TRAILS AT ASPEN RIDGE

PLANNED UNIT DEVELOPMENT AND SITE PLAN MAJOR AMENDMENT - TRAFFIC IMPACT STUDY

El Paso County, CO

Figure 4 - Buildout Year Total Traffic with Project

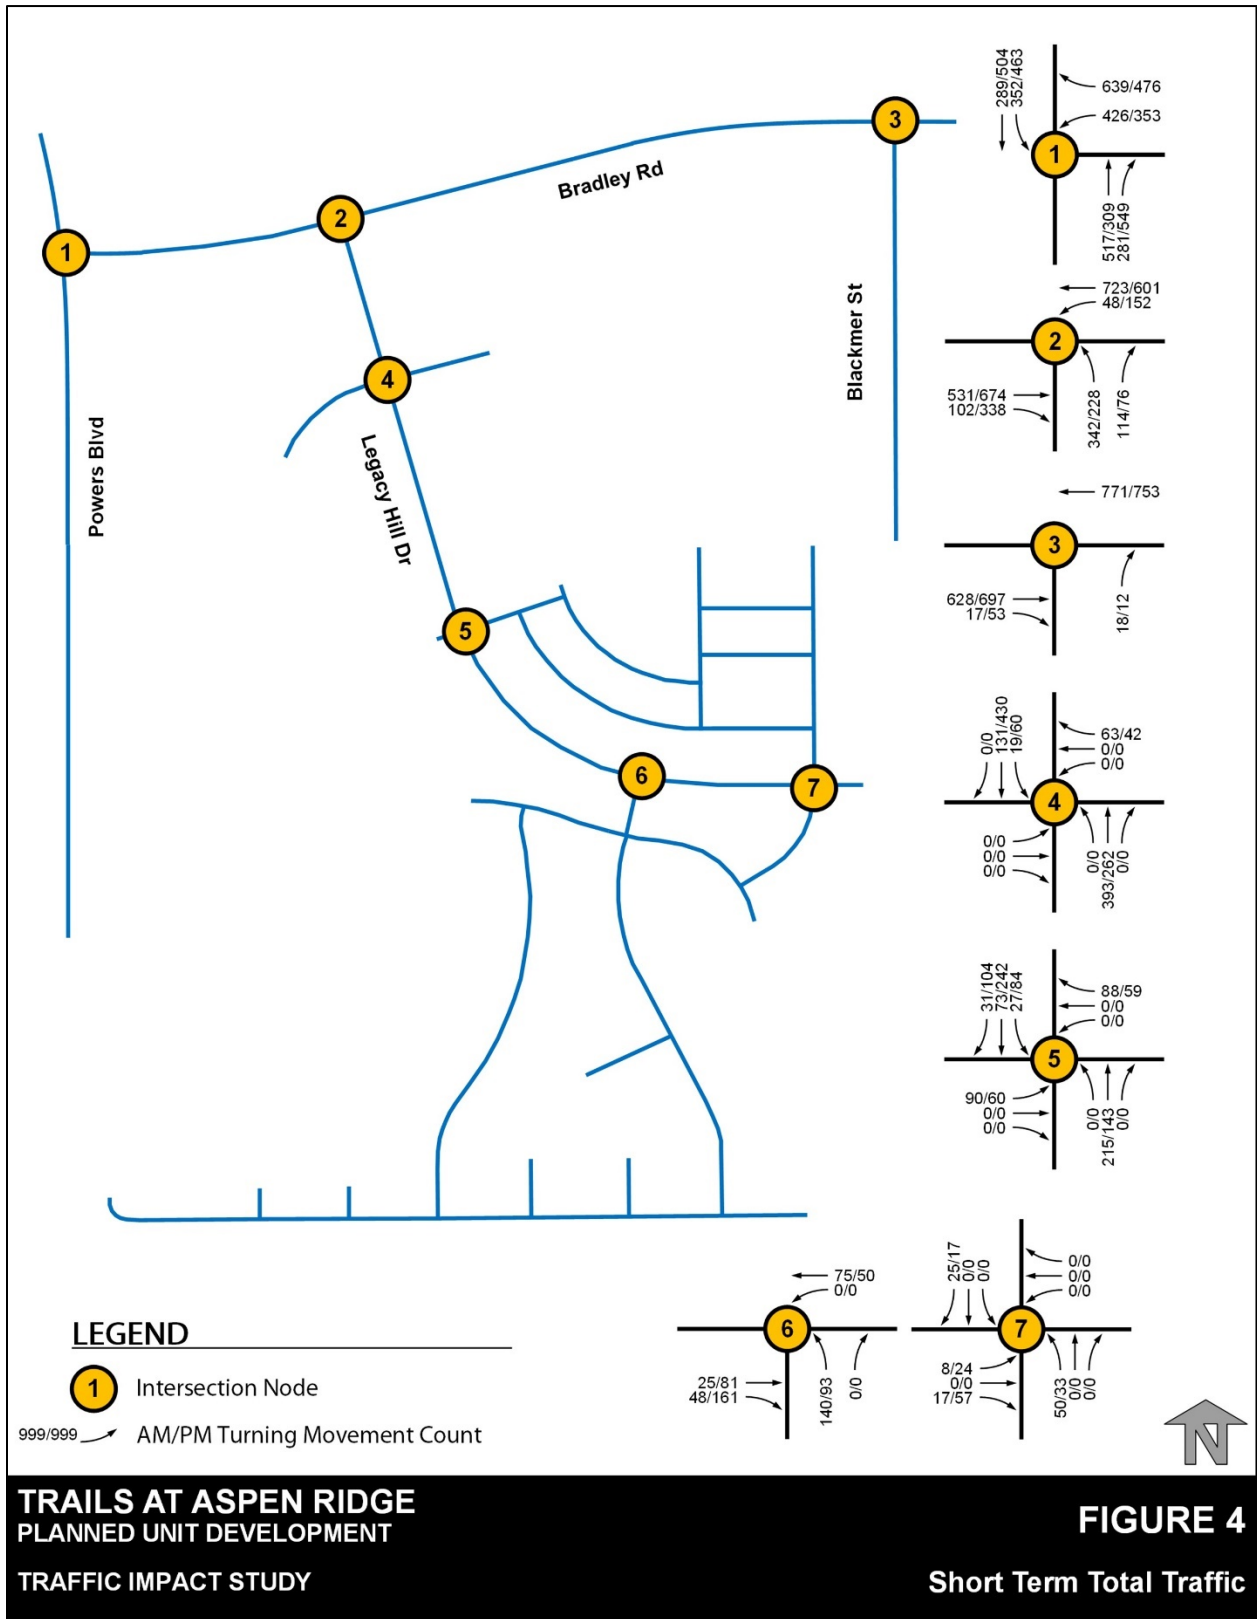
Since the prior study application a sketch plan amendment and rezone has been submitted which may impact the assumed background traffic volumes and trip distribution within this TIS.

See PCD File No.'s SKP202 and P202. If no changes are made based on these proposed amended use & rezone then provide narrative with justification.

Figure 7 - 2040 Total Lane Configurations & Traffic Control

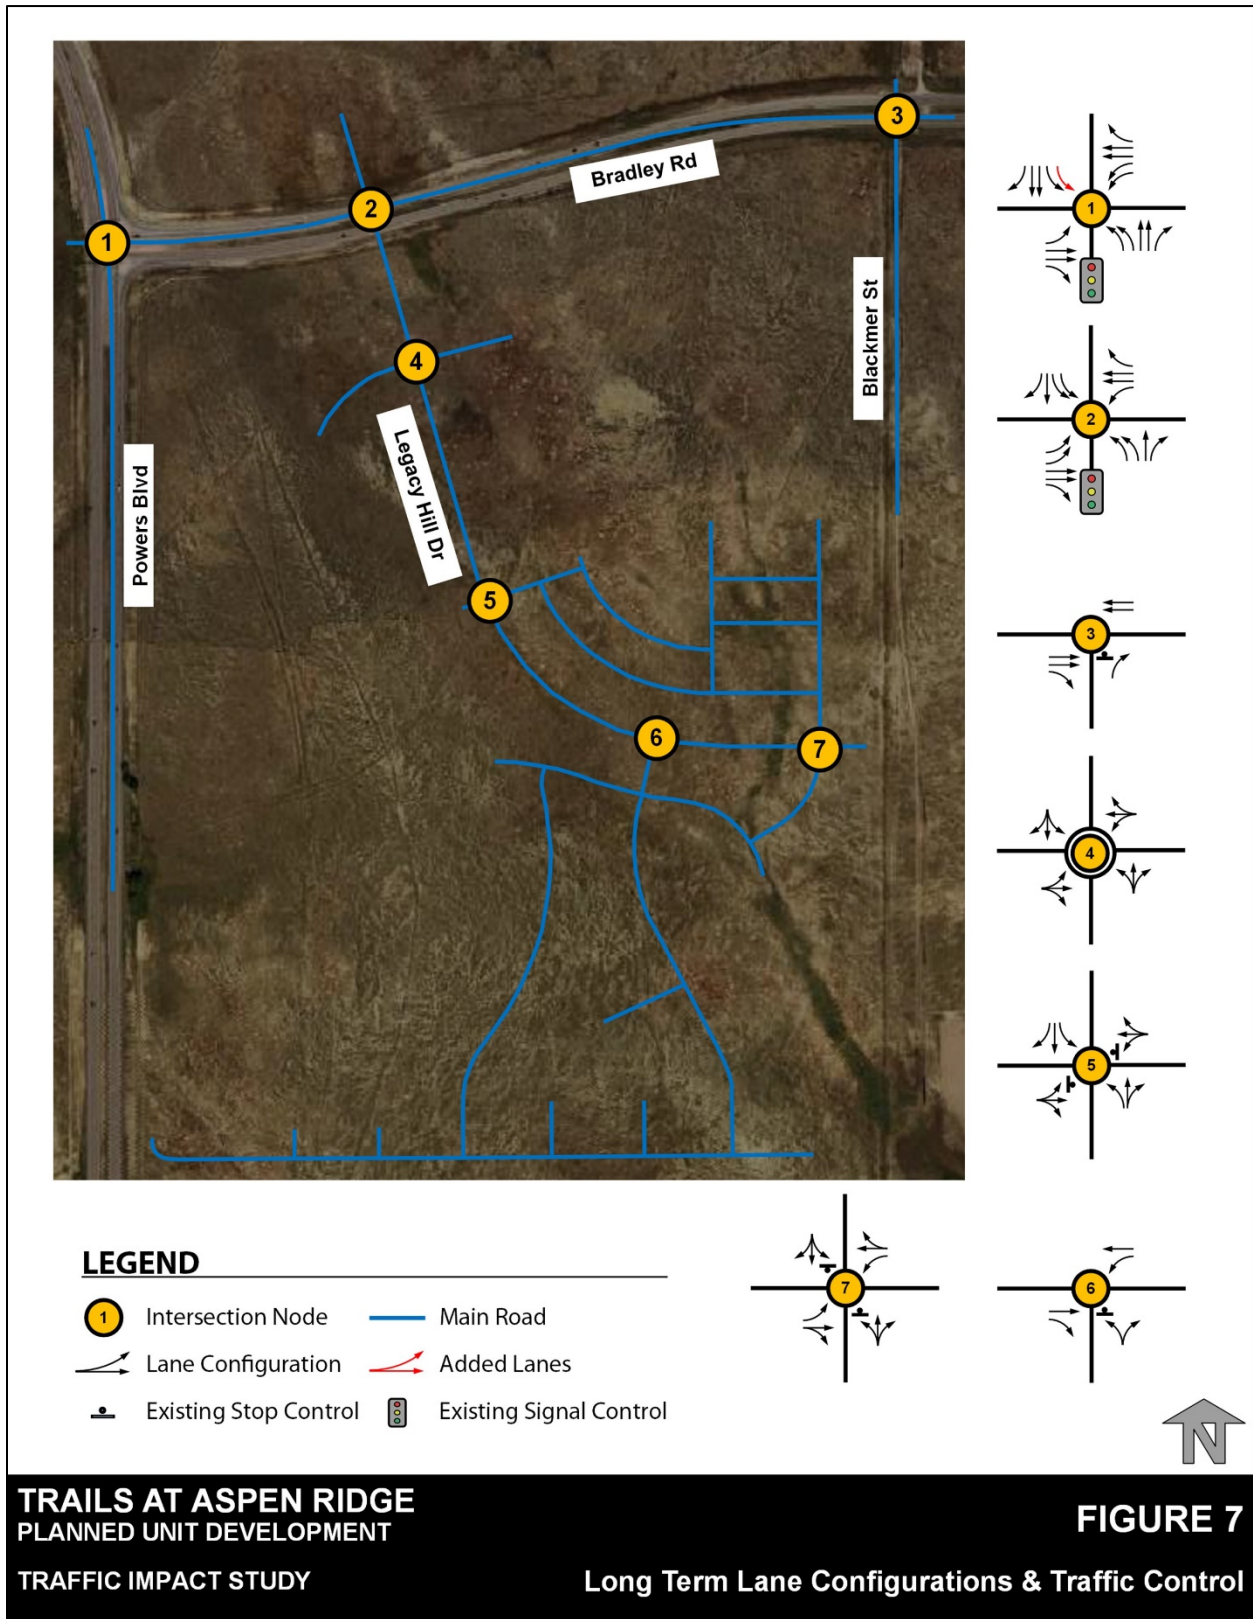
Ad a footnote on the table describing the (*) symbol

Update. These recommendations appear to be for Bradley Road/Powers Blvd

Provide recommendation for the intersection lane configuration at Bradley/Legacy Hill, specifically the chevron area.
